Y/98/20/PL

Bonhams Field Main Road Yapton BN18 0DX

Erection of 75 No. dwellings with associated parking, public open space & the creation of a new vehicular access. This application affects the character & appearance of the Main Road/Church Road Conservation Area & affects the setting of listed buildings.

Image showing proposed revised layout plan

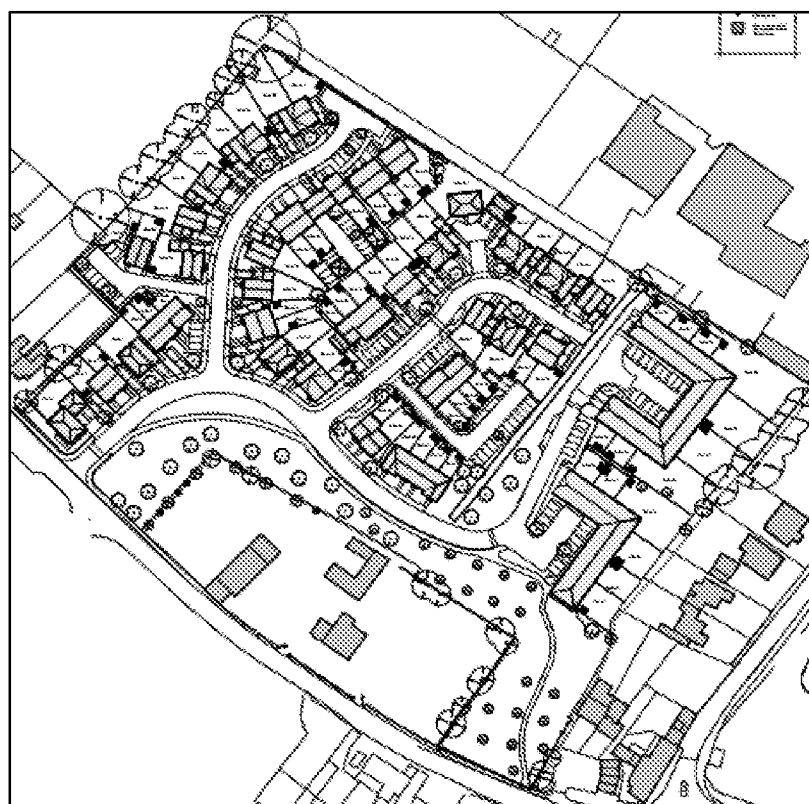
For instance, plots 55-60 are essentially modern terraced houses, that could be built anywhere. However, it is noted that they do have brick elevations with a clay roof, which if constructed using appropriate materials, could be more acceptable. The use of traditional materials (as opposed to standard ones) would also help to soften the impact of the building. Details such as the materials, style of windows and the position of the windows in their openings (which create shadow lines) will help to improve the appearance of the buildings.

The site plan creates the feeling of a modern housing estate which fails to successfully integrate into the existing built form and historic grain of the village as can be seen in the conservation area. This is unfortunate, and is out of character, especially for a key edge of village location such as this.

Good design should not be screened but enhanced through carefully prepared landscaping schemes. The current proposal maintains the open space around two of the closest listed buildings, which is positive. This open space should be such that there is an acceptable distance between the closest new homes and the various heritage assets. Likewise, it should be carefully

landscaped so as to not create a sub-urban character. It is suggested that mature trees are incorporated into the open space in order to ensure that the impact on the setting of the heritage assets is minimised. If the layout and detail of the open space is considered to be acceptable, please ensure that these trees should be of relevance to the local area.

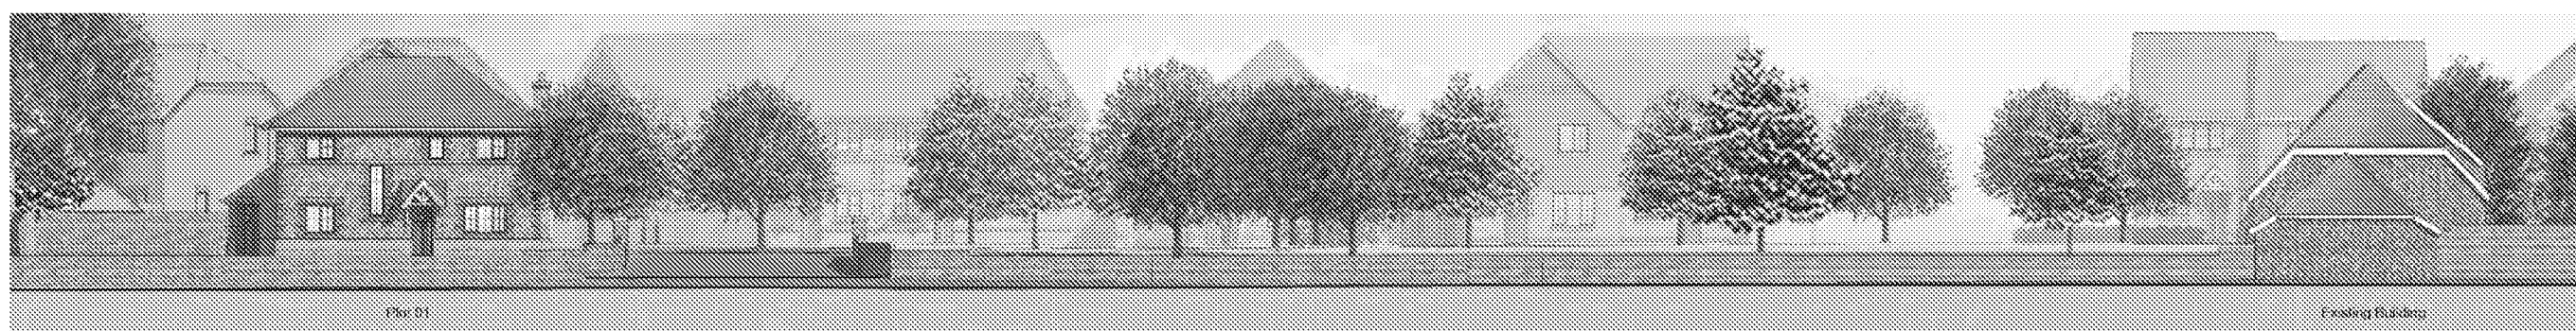
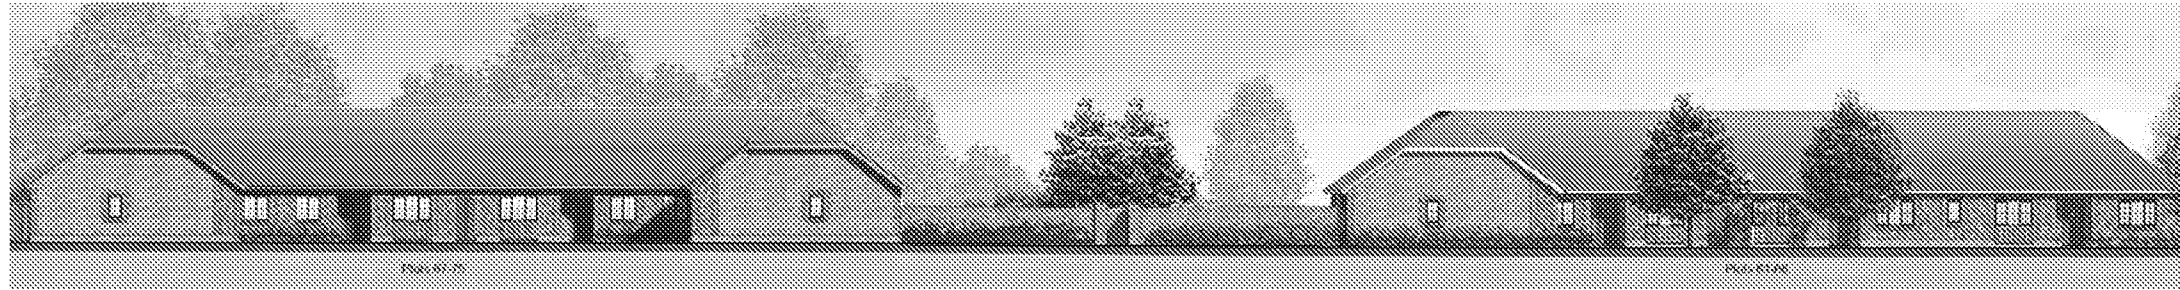
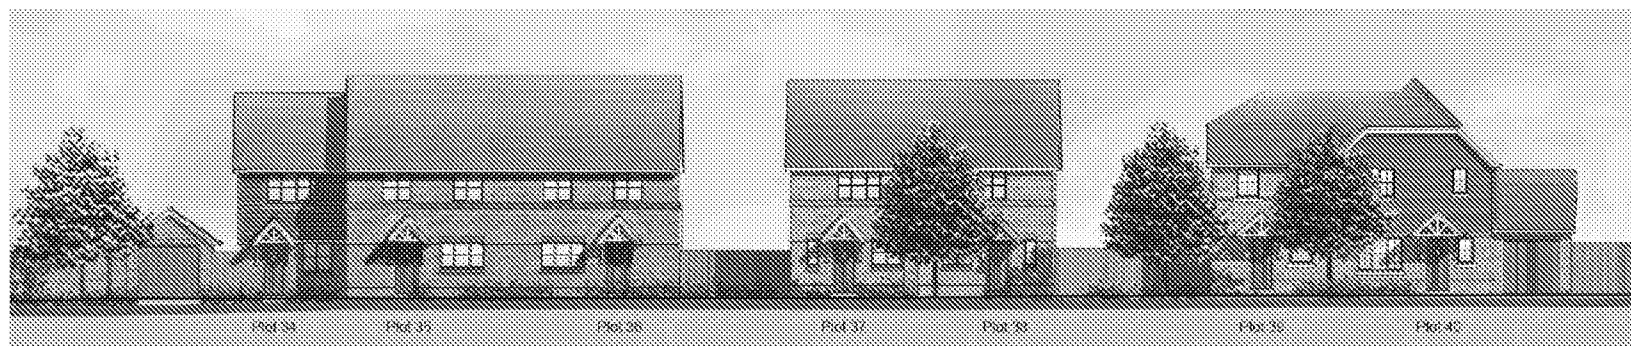
The street-scene provided for the element of the scheme fronting on to Yapton Road indicates that a good number of properties would be visible from the road, the conservation area and in the context of the listed buildings. Their size, and height, when compared to the listed buildings, will mean that they would appear to be somewhat larger than some of these assets, and clearly visible in their context. This is unfortunate and harmful to the settings of the listed buildings.

The provision of a number of trees in the open space will reduce the impact of these units, but it is thought that the houses will still remain fairly dominant in the street-scene. This is unfortunate and harmful.
